KIRKLEES METROPOLITAN COUNCIL INVESTMENT & REGENERATION SERVICE

DELEGATED DECISION TO DETERMINE PLANNING APPLICATIONS

Reference No:	2026/62/91796/W
Site Address:	159, Deighton Road, Deighton, Huddersfield, HD2 1JT
Description:	Formation of vehicular access
Recommending Officer:	Joshua Merriman

Officer Report – 2026/91796

Driveway 159 Deighton Road

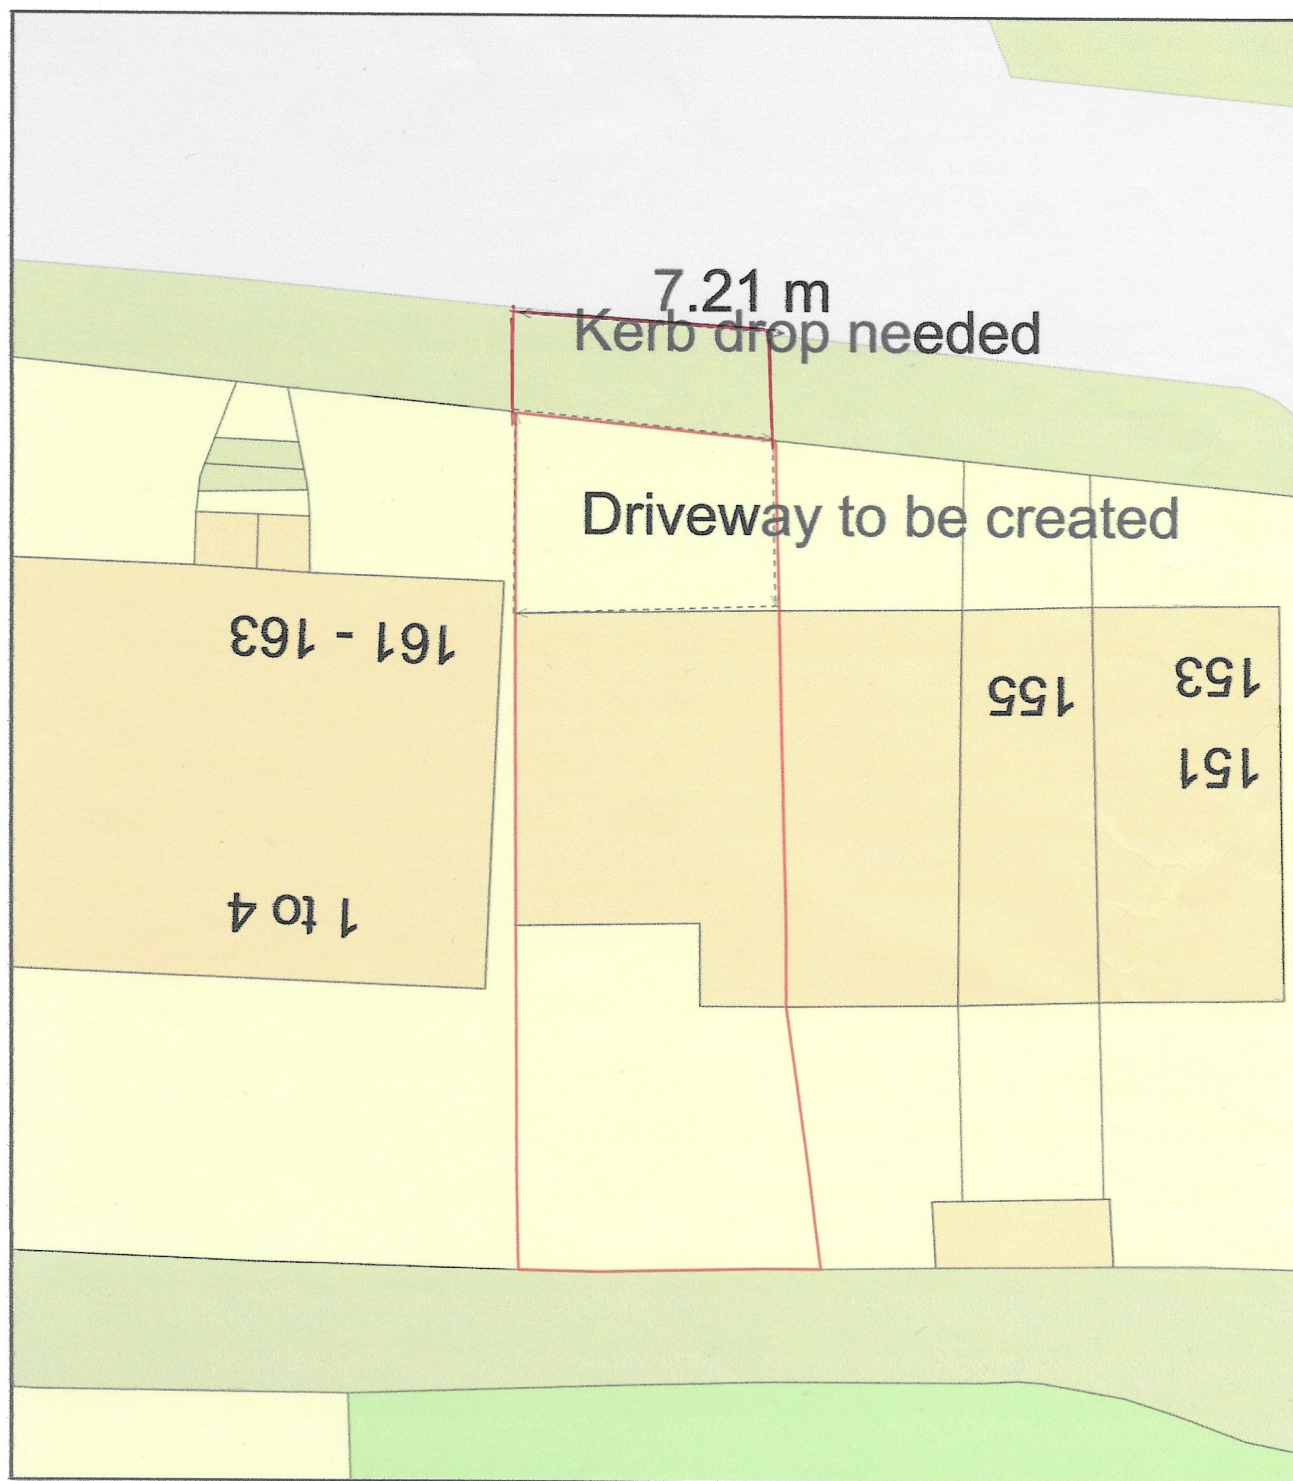
It should firstly be noted that the hard-standing parking area proposed would not meet the dimensions necessary as per the Highways Design Guide SPD in all areas. The area of hard-standing closest to neighbouring properties No. 161-163 would meet the criteria set out, however, the driveway area neighbouring No. 157 would not be large enough for a vehicle to be kept.

Following an informal consultation with KC Highways Development Management, it was considered that the parking area would be suitable for one vehicle, and given this is an improvement on current off-street parking arrangements, which do not currently exist at the dwelling, the proposal would be supported as it removes vehicles from the highway.

It should be noted that the applicant has submitted a parking plan detailing that the driveway will only be occupied by one vehicle, removing any animosity around the usage of the hard-standing area and ensuring it is suitable in terms of dimensions.

There are no specific details within the submitted plans for the storage or presentation of waste. Any bin storage to the front will further restrict the parking of vehicles.
